TII26-135854

Re: Strategic Infrastructure Development Application for the Proposed Carrow Windfarm including 14 wind turbines, 110kV underground cabling connection, and all associated infrastructure, Co. Tipperary and Co. Limerick

ACP case ref. PAX91.324164

Figure 15-6a Proposed cable grid connection route

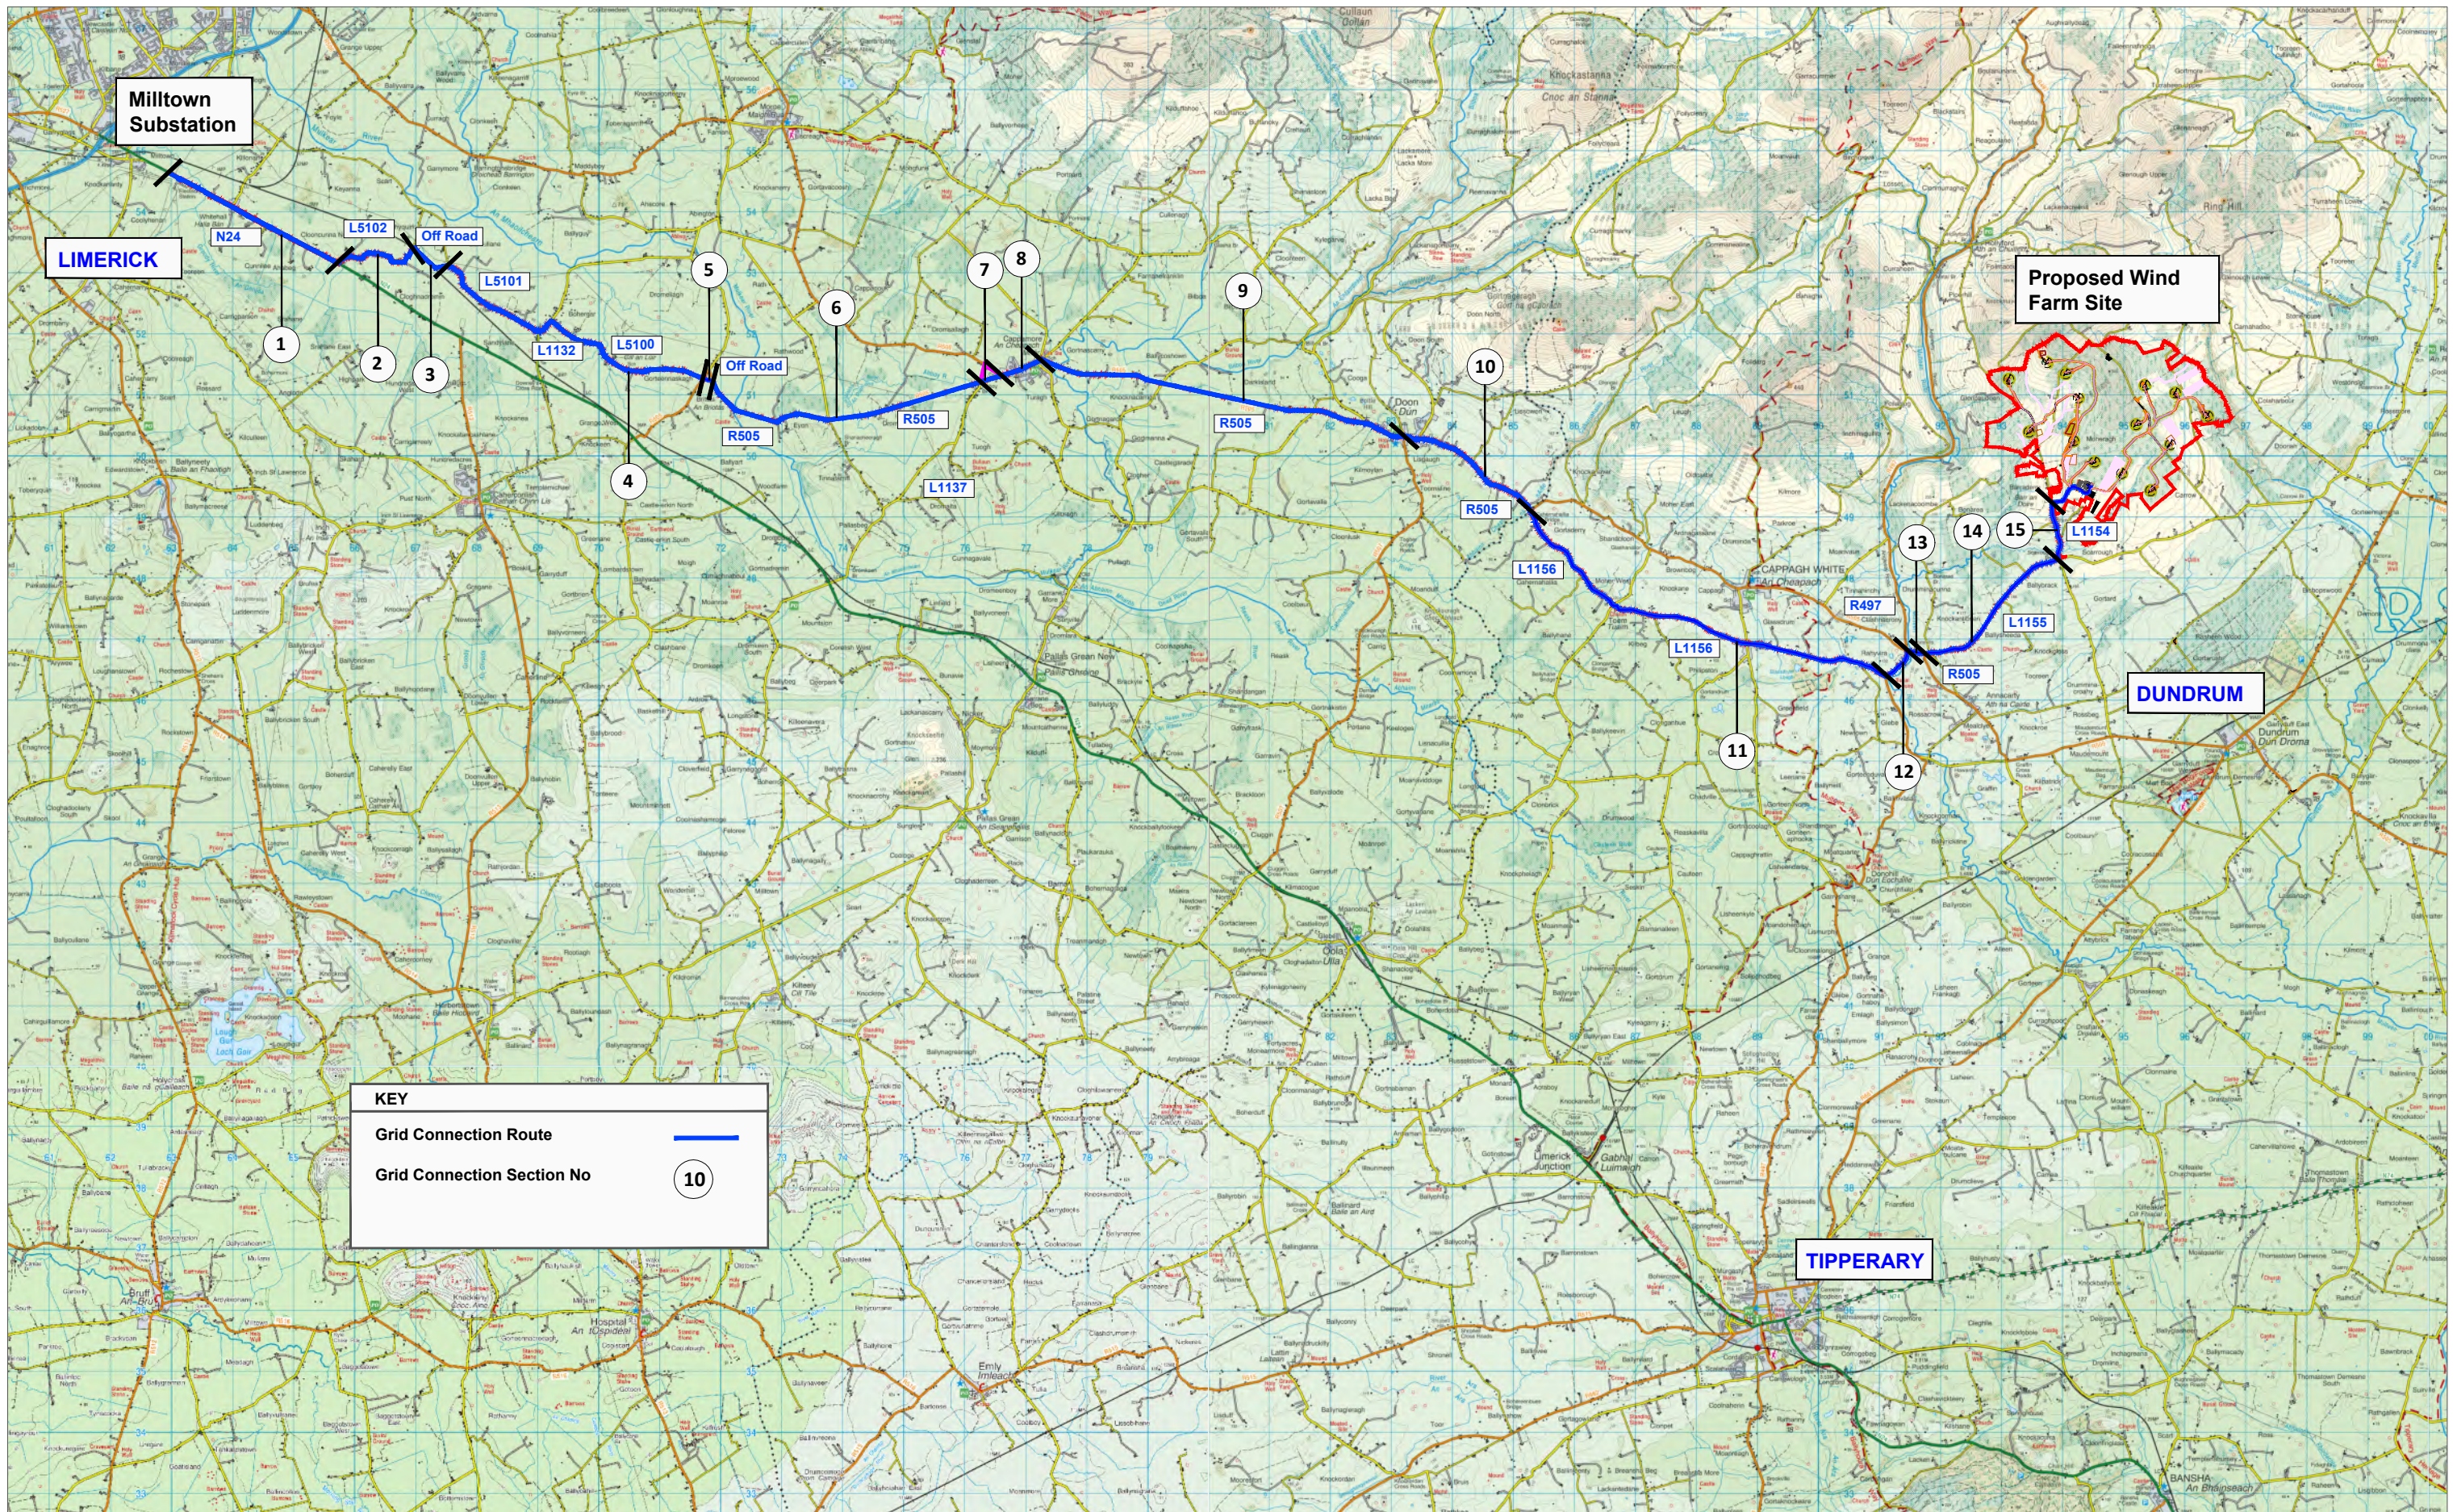
In relation to the specific application, proposals for a c. 37.6km grid connection cable routing between the proposed on-site Substation and the Killonan 110kV substation are identified. Table 15-28 indicate 3.1km of the proposed grid connection routing is proposed in the N24, national road, reservation. Within that 3.1km section of national road concerned, Section 4.3.2.4.1 of the EIAR submitted indicates proposals for 5 no. joint bays.

TII also confirms that the grid connection routing within the section of N24, national road, corridor concerned involves a crossing of TII Structure ID LC-N24-007 (Whitehall Bridge).

TII has identified a number of significant implications for TII and road authorities in the management and maintenance of the strategic national road network resulting from the laying of high voltage electricity cabling in the national road reservation, including;

- Impacts on embankments, bridges, drainage and road furniture infrastructure leading to future maintenance liabilities,
- Impediments to future maintenance and operations activities, such as safety barrier repair and French drain renewal,
- Impediments to future routine network improvements such as pavement overlay and strengthening, installation of new verge-side signs and other road furniture,
- Impacts on network traffic flows during installation,
- Impediment to future on-line upgrades of national roads because of the implications to road authority / TII in having to incur the additional costs of moving underground cables in order to accommodate the road improvements.

Having regard to the measures identified in CAP24 and the information in relation to grid routing included in the subject application, TII recommends that the Commission be satisfied that the proposed grid routing represents the optimal routing solution.

'Crossings of all national road structures shall be by HDD only. All standards for grid connection cable construction and associated infrastructure in the public road shall be agreed with the Road Authority prior to the commencement of any development.'
